CITY OF ALBUQUERQUE

Re: Office Warehouse for McClintic RDM 9700 Trumbull, Traffic Circulation Layout
Engineer's Stamp dated 6-17-14 (L20-D051)

**SUBJECT: TRAFFIC CIRCULATION LAYOUT
OFFICE WAREHOUSE FOR McCLINTIC RDM (L20-D051)**
9700 Trumbull Avenue SE
Albuquerque, New Mexico 87123

SITE PLAN
SCALE: 1" = 20'-0"

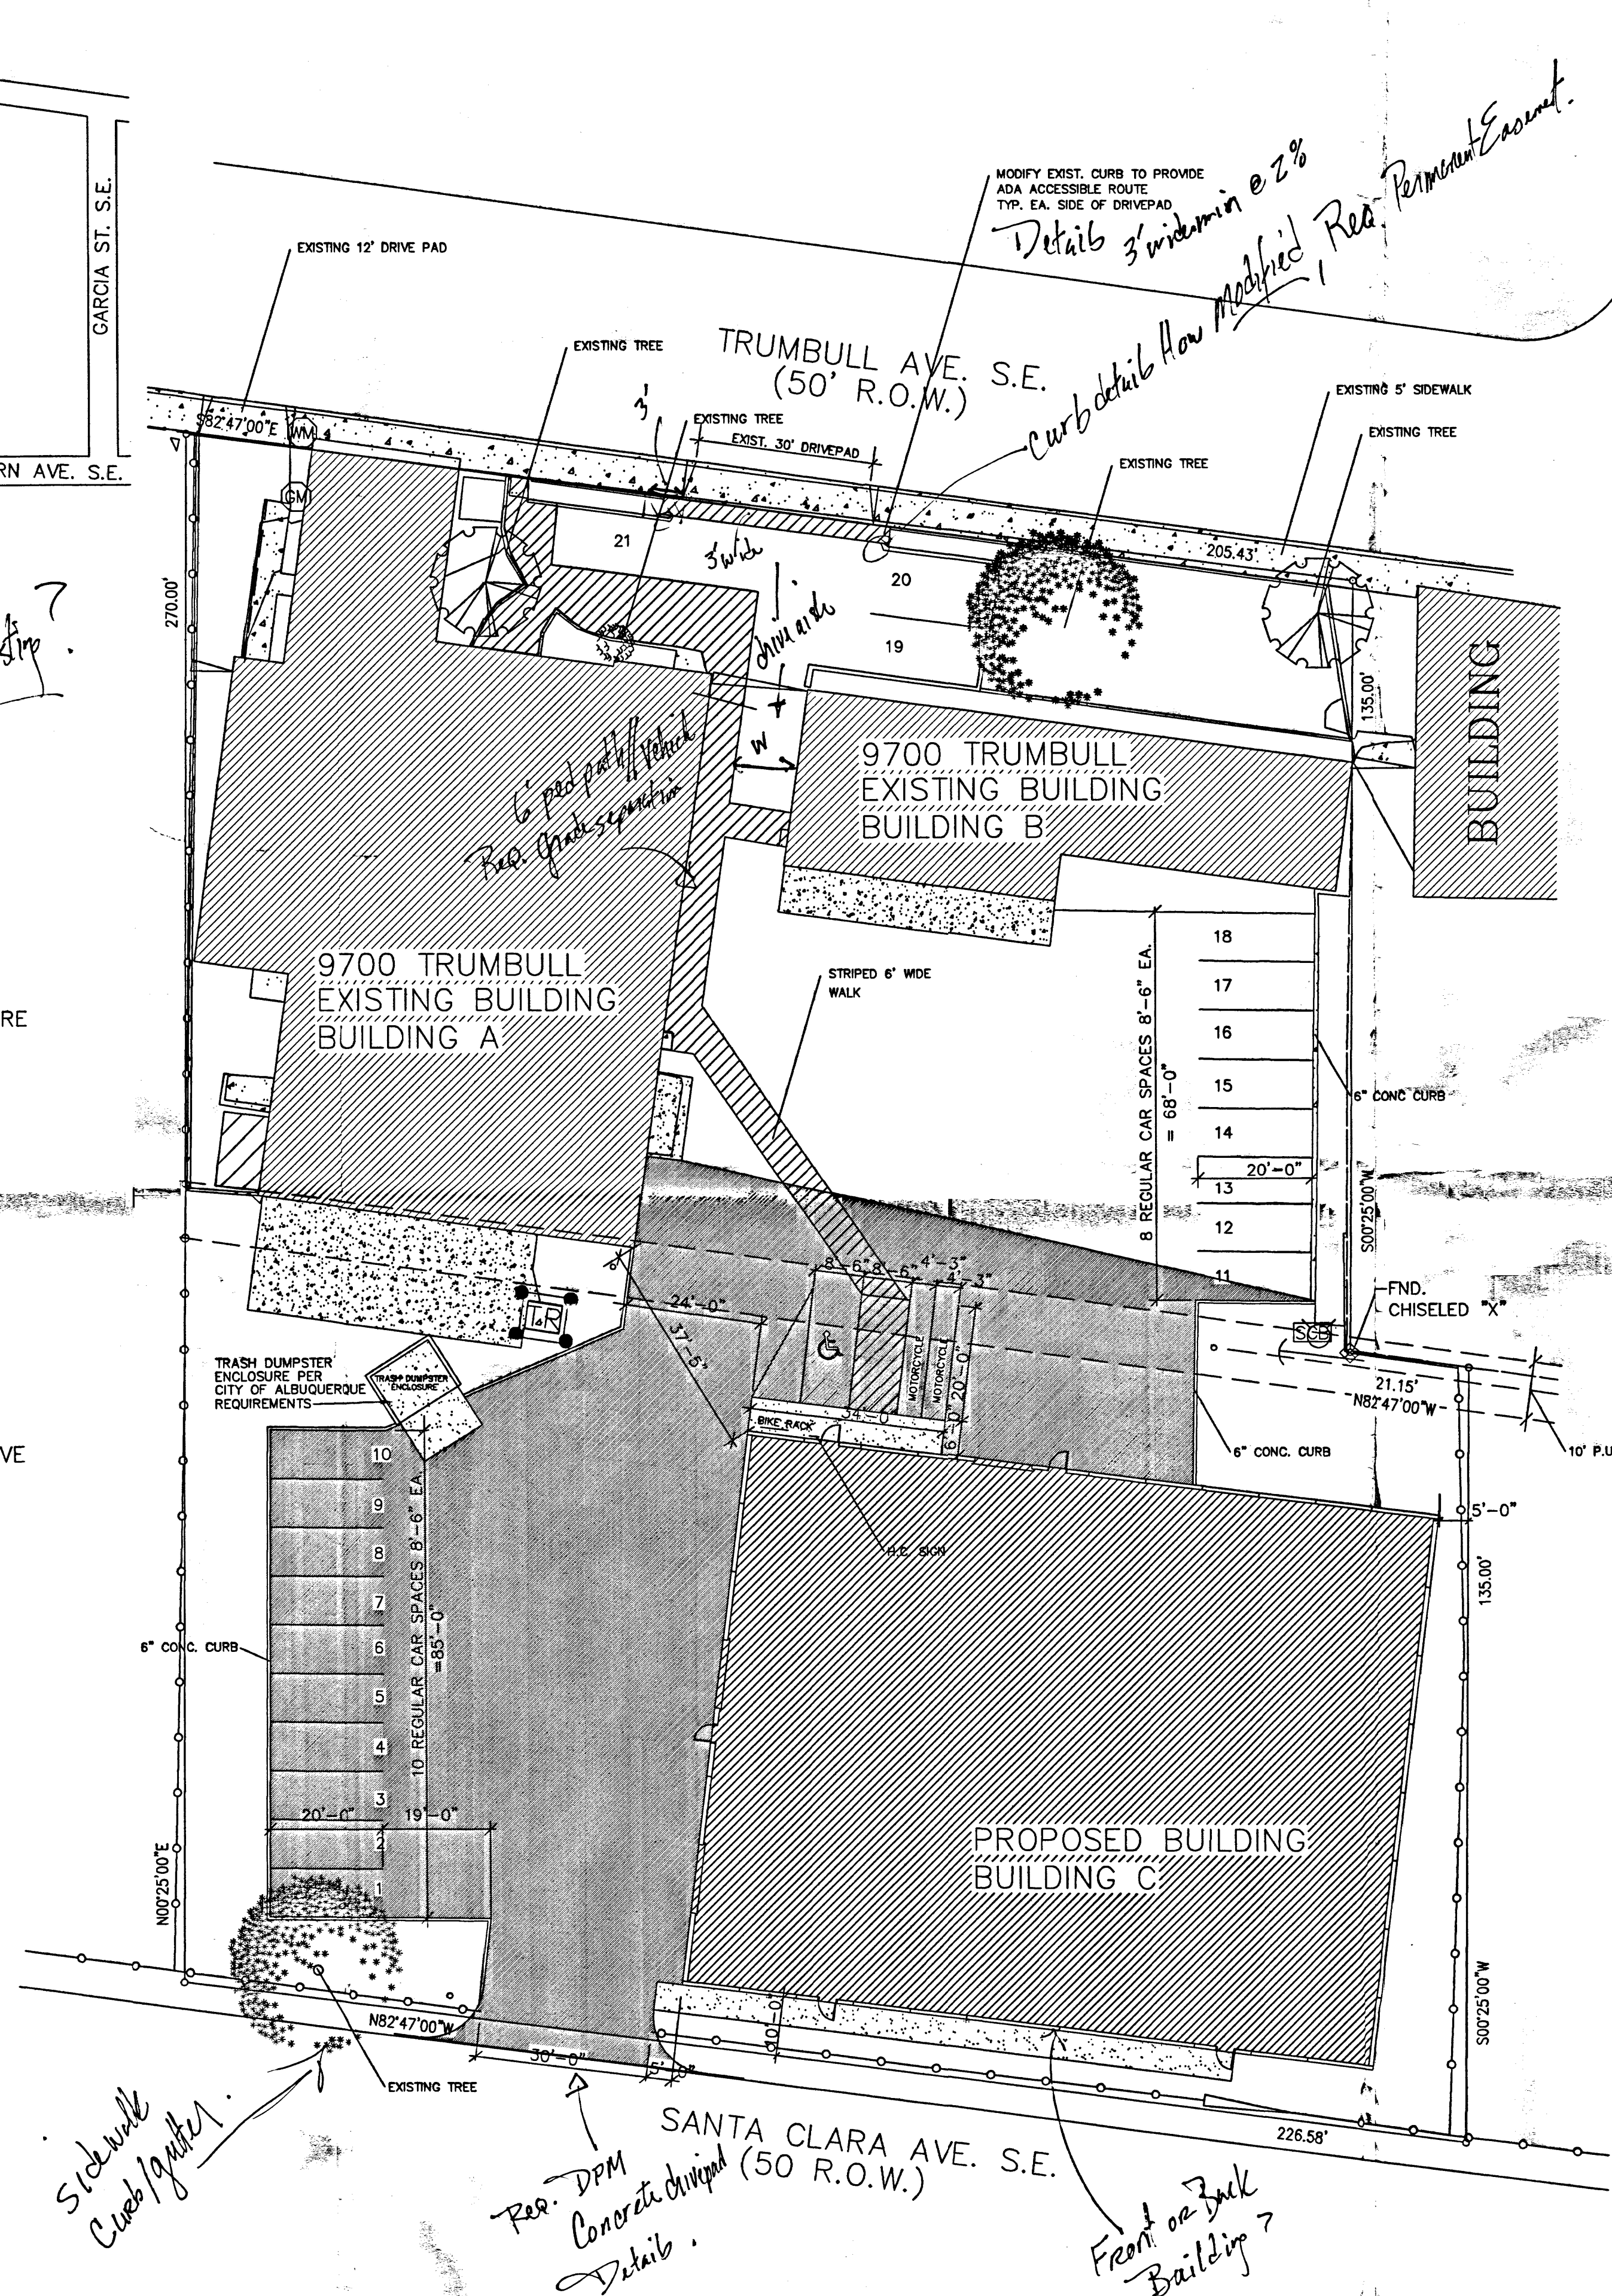
1. The Plan is in compliance with DPM and ADA standards.
2. Applicable City standards are referenced where necessary.
3. The proposed 6-foot wide pedestrian way has been modified to connect the new building entry to the rear entry of existing Building "A". A striped pedestrian link is also provided from the existing front entry of Building "A" to Trumbull.

4. The distance between Buildings "A" and "B" is dimensioned.
5. The project entry will be modified to provide ADA accessibility per DPM. Detail 4 is provided to detail a 3-foot wide ADA pedestrian path around the existing driveway, within a 4-foot wide public sidewalk easement.
